July 20, 1989

REFERENCE: Drainage Plan for Second Presbyterian Church Addition
(J-14.D84)

This letter is in reply to your comments provided by letter dated July 18, 1989, subject as above. The paragraph numbers below correspond to the question numbers in your letter.

GRADING AND DRAINAGE PLAN
ADDITION TO 2ND PRESBYTERIAN CHURCH
808 EDITH BLVD. N.E.

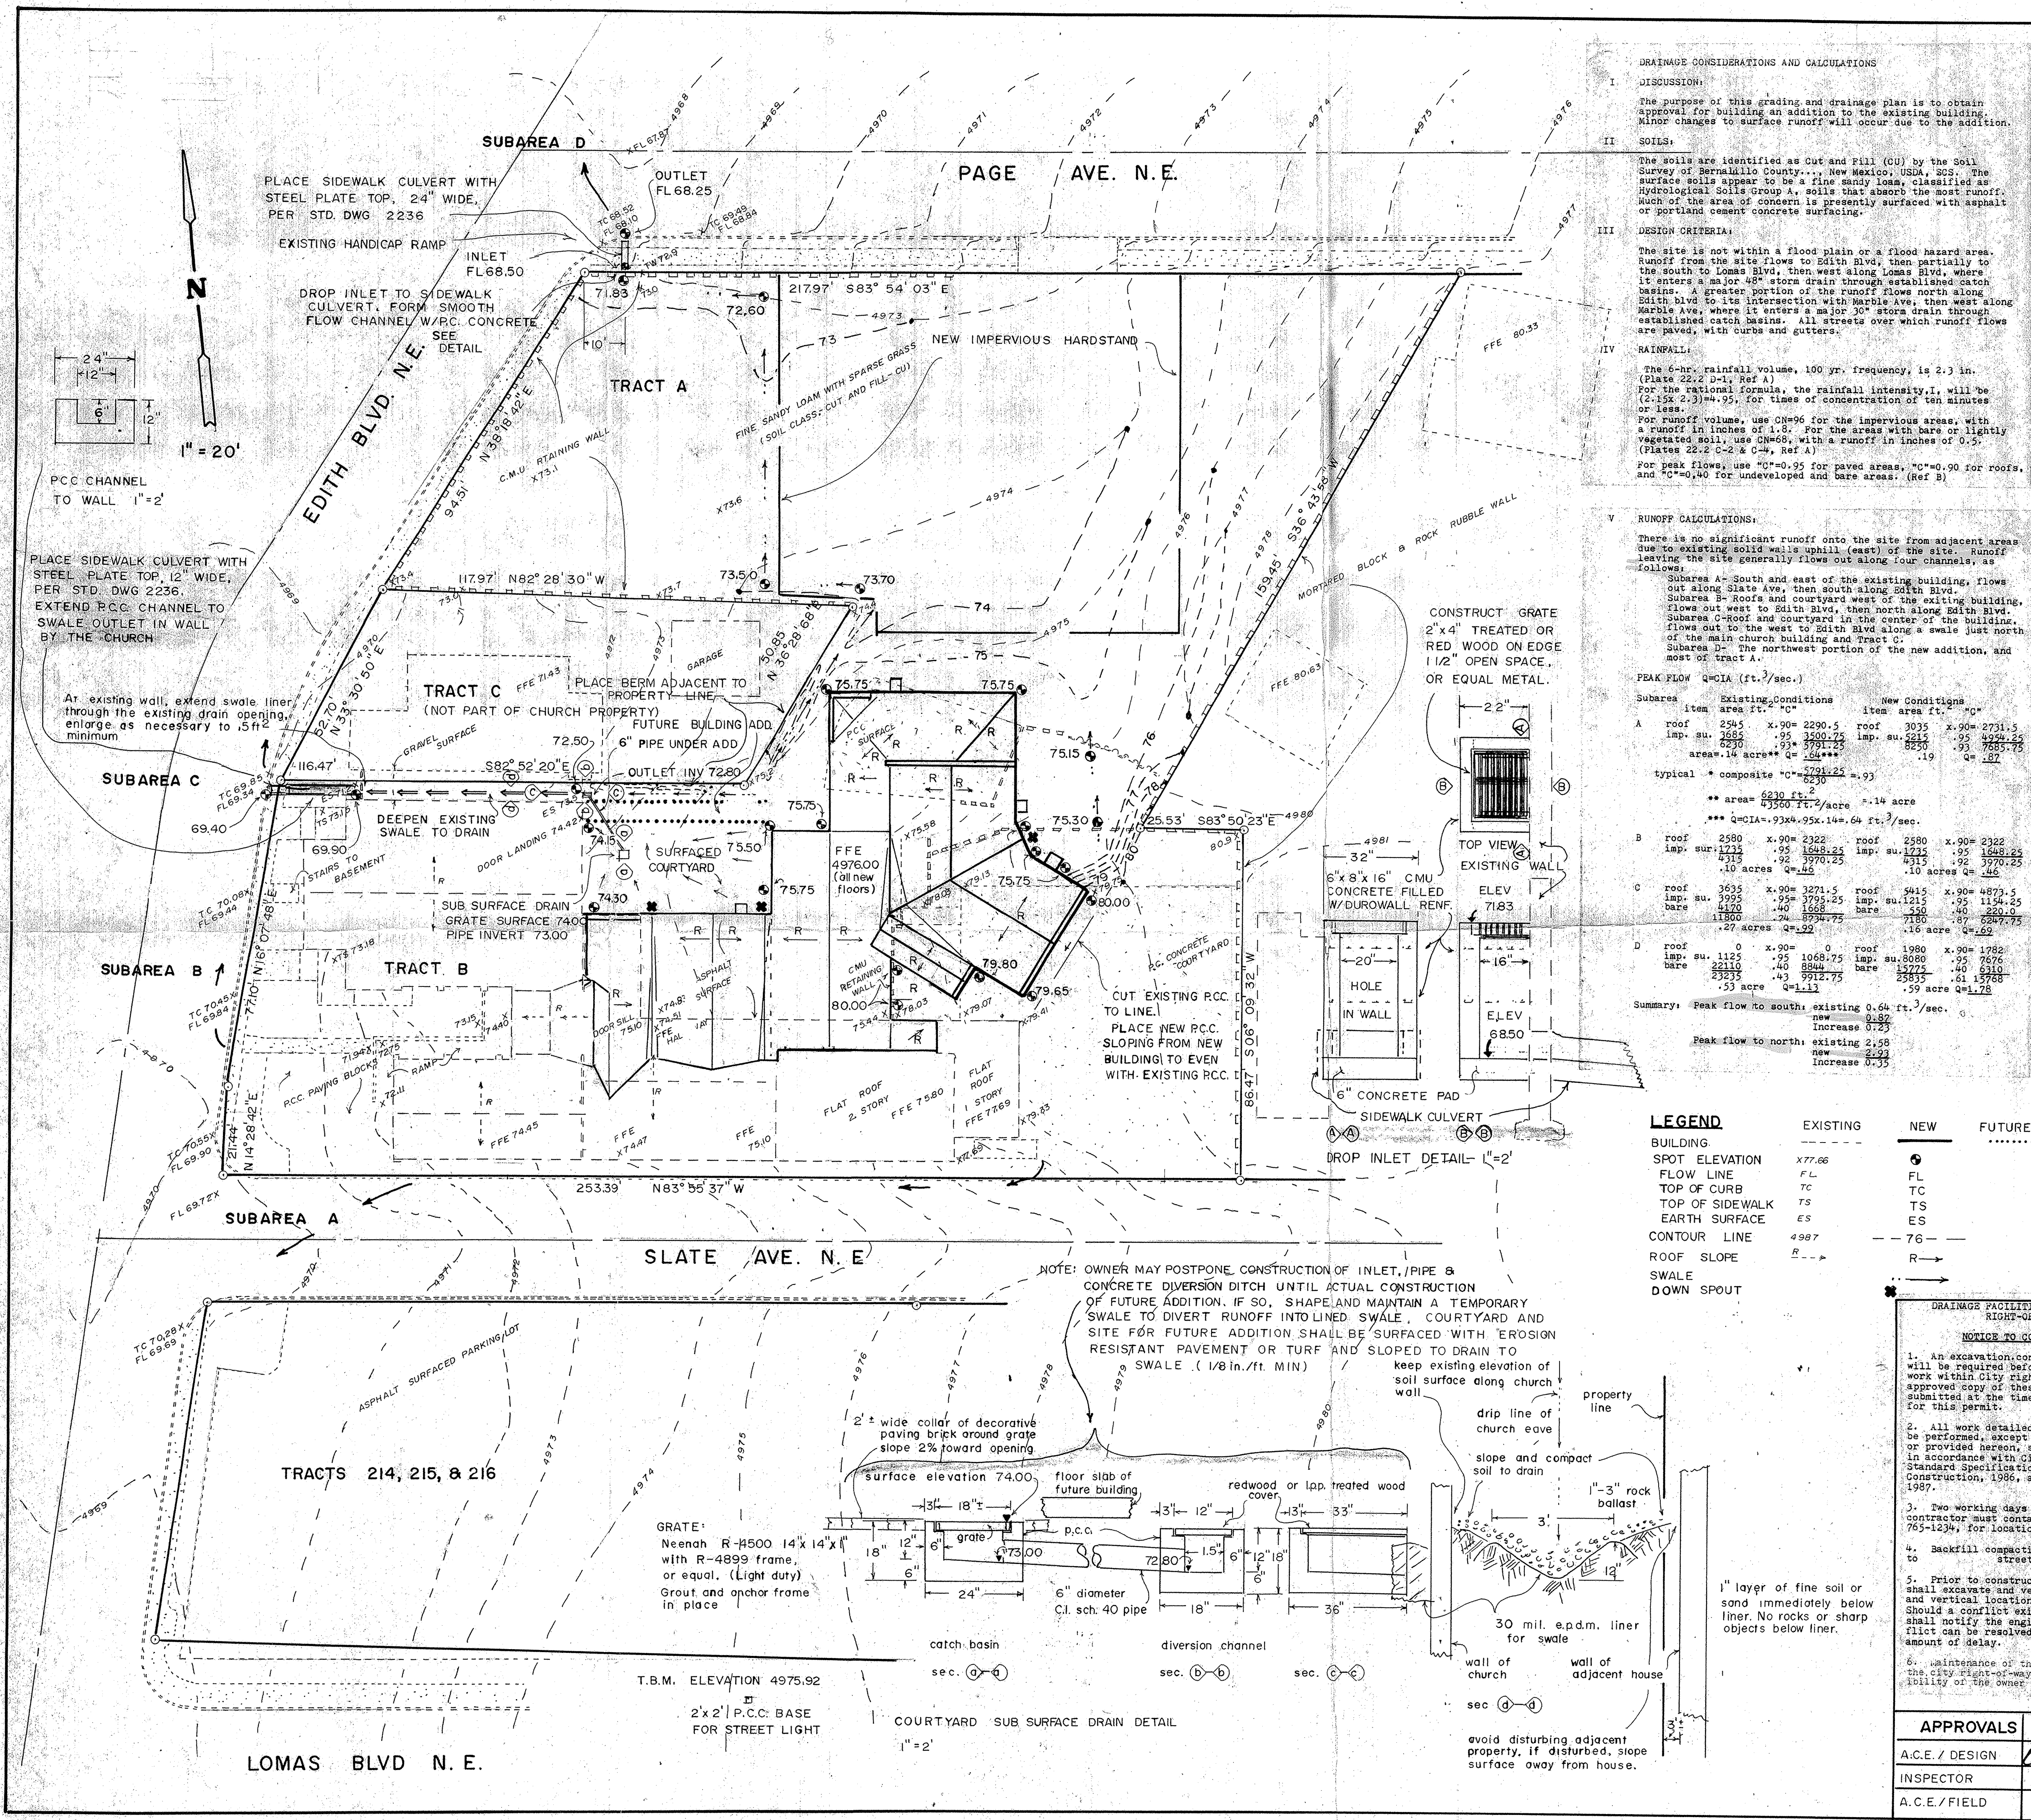
1. The finished floor elevations of the new addition are all 4976.00, except for steps and ramps which are necessary to transition to the various elevations in the older building.

2. Detail of the notch in the block wall at the sidewalk culvert on Page Avenue are now shown.
3. The option of placing the underground pipe and inlet at a later date are now noted on the drawing. A note also indicates that a swale will be placed if the owner elects to not place the pipe at this time.

4. I request your reconsideration of the requirement for a more permanent swale immediately north of the main church building. First, the present swale is unlined, and has not created any notice of a problem. Second, the flow estimated for the addition is less than that estimated for the present configuration. The reason for adding the liner at this time is to preclude any threat of litigation should a problem develop related to the new construction. Third, the church hopes to eventually purchase the adjacent property, so the present solution can be expected to be in place possibly 5 to 10 years. Fourth, I believe that the proposed liner is a durable and economical material. Test show the membrane can withstand 300% stretching without breaking. During construction, The material will withstand minor abuse, such as walking on it or dropping of hand tool, and placing of rock, which must be done by hand due to the limited work area. After the rock is in place, of course, the material is much less subject to abuse. The rock cover can be brought to a fairly level and stable configuration. The area is also not subject to any significant pedestrian traffic, the area is fenced and locked routinely. It is also noted that the material could have minor punctures and still function as an effective swale liner. Leakage during the brief periods that water is flowing across the membrane will be very little. It is not intended to perform as a pond liner in the called for construction. Attached is a sample of the material for your inspection.

5. The flows from the end of the lined swale are now to be conveyed to Edith Blvd. by a channel and under sidewalk culvert, this change being made as a result of your comment.
